DRB Project Number: 2021-005714  
4000 2<sup>nd</sup> Street NW

SUBJECT: Preliminary/Final Plat

**Project Name:** Lot 1-A Monkbridge Addition

**Request:** Preliminary/Final Plat

PLAT
OF
LOTS 1-A
MONKBRIDGE ADDITION
PROJECTED SECTION 5 T10N, R3E, N.M.P.M.
WITHIN THE TOWN OF ALBUQUERQUE GRANT
ALBUQUERQUE, BERNALILLO COUNTY, NEW MEXICO
JUNE 2021

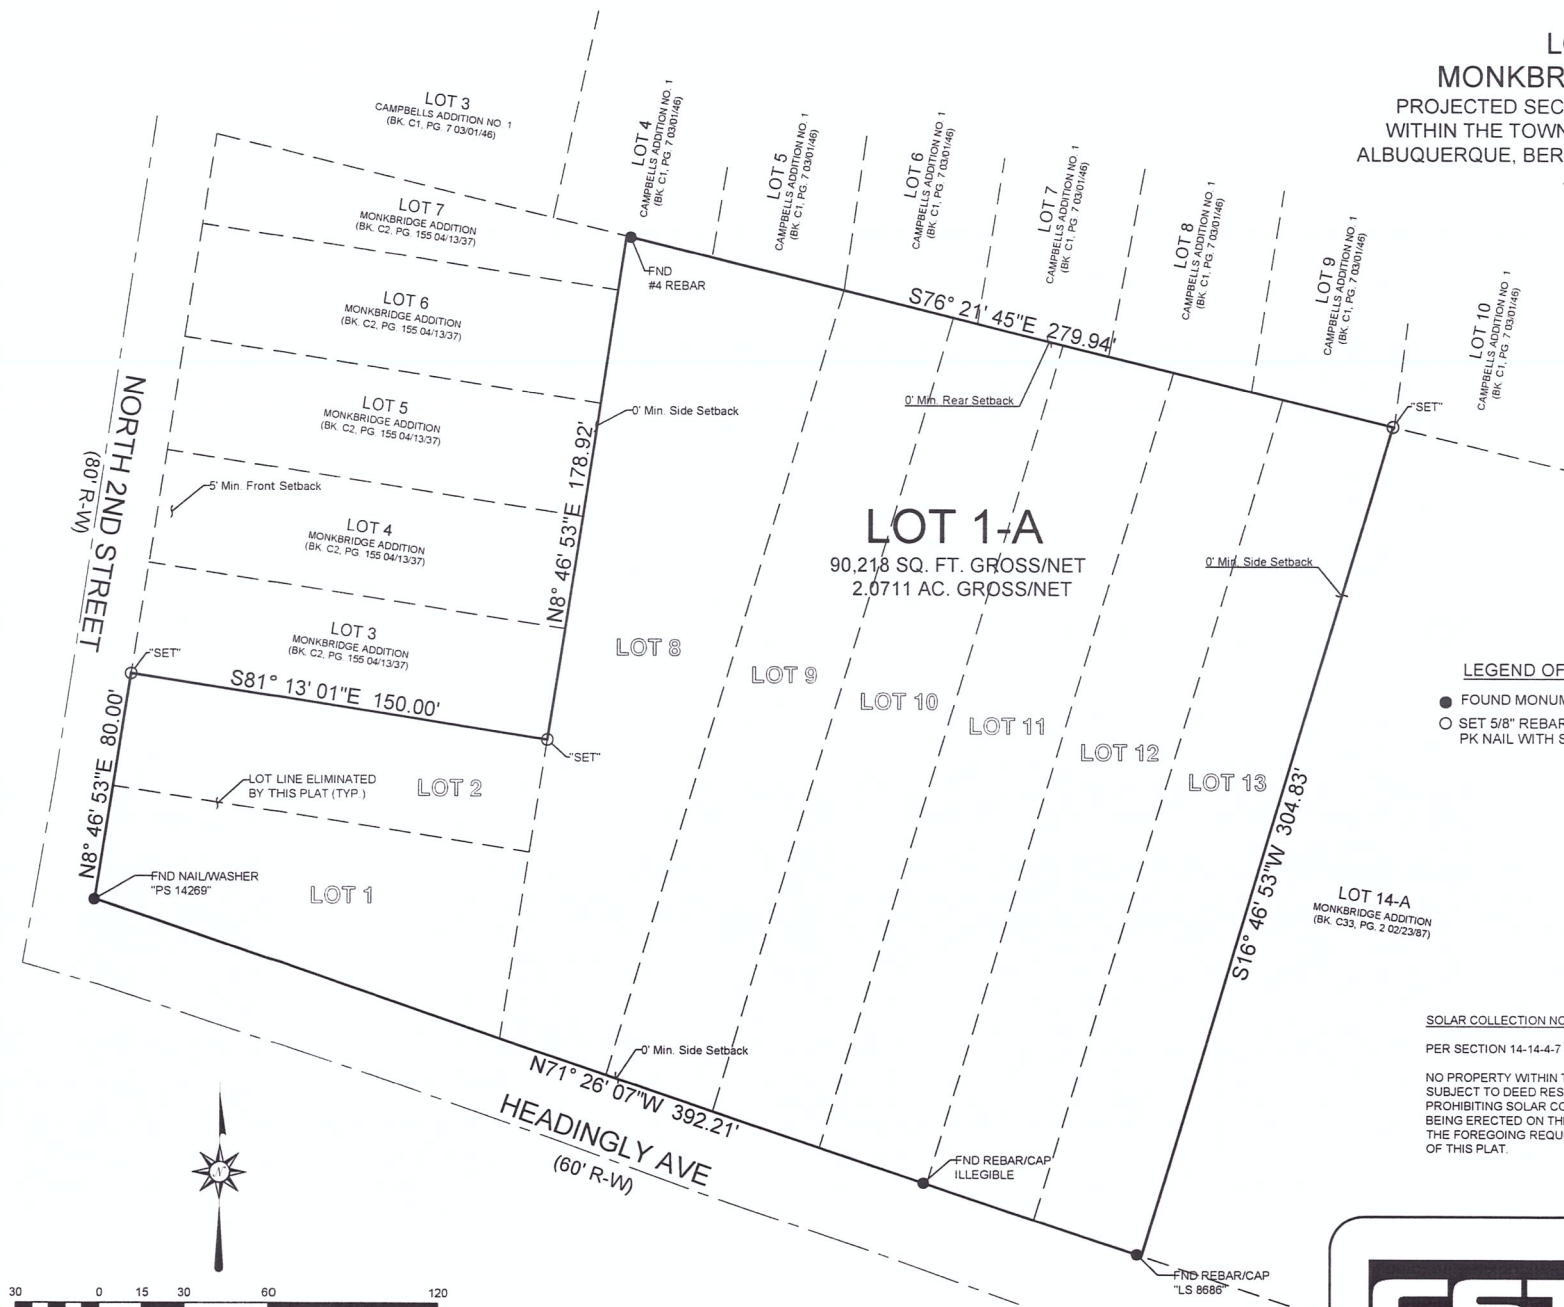
1. Show existing sidewalk widths and distances from curb to right-of-way. Right-of-way dedication may be required on Headingly or 2<sup>nd</sup> Street. Your sidewalk exhibit does not show widths or distance to from curb or right-of-way.
2. 2<sup>nd</sup> Street is a Principal Arterial and requires a 6-foot sidewalk with a 5-6 foot landscape buffer along the frontage. Provide an exhibit showing proposed sidewalk, and provide additional right-of-way width for the bus stop to allow for a future bus shelter. There is a proposed bike lane along 2<sup>nd</sup> Street, please provide a cross section to show that it will fit in the existing right-of-way or right-of-way dedication may be required
3. Headingly is a Local road and requires a 5-foot wide sidewalk with 4-6 foot landscape buffer.

- This proposed Plat would consolidate 8 existing lots into a single lot (Lot 1-A) a total of 2.0711-acres in size.
- **\*Please confirm ROW development and any changes. Include compliance detail for section 7 of the DPM Table 7.2.29 regarding Sidewalk width requirements and its landscape buffer.**

- \*Verification of standards per Transportation\***
    - Headingly Ave NW is a local street, requiring a 5-ft sidewalk and 5-6-ft landscape buffer
    - 2<sup>nd</sup> Street NW is a minor arterial, requiring a 6-ft. sidewalk and 5-6-ft landscape buffer.

- All standards within IDO section 5-4 Subdivision of Land and 5-4(C) Compliance with Zoning Requirements apply to platting actions.  
**\*Confirm that no new nonconformities will be created with replat.**
